Reason for application being invalid:

| <input checked="" type="checkbox"/> | Inadequate Plans | The following additional plans are required: |

Proposed Gable Elevation
Scale 1:100

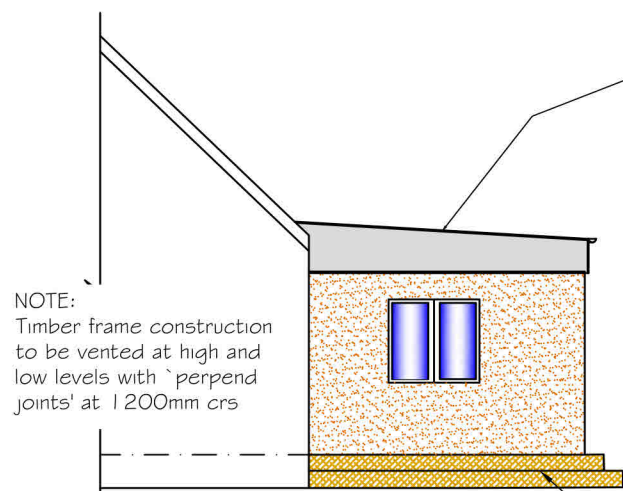
- Please provide a proposed roof plan
- Please provide a side elevation or section of the patio/steps
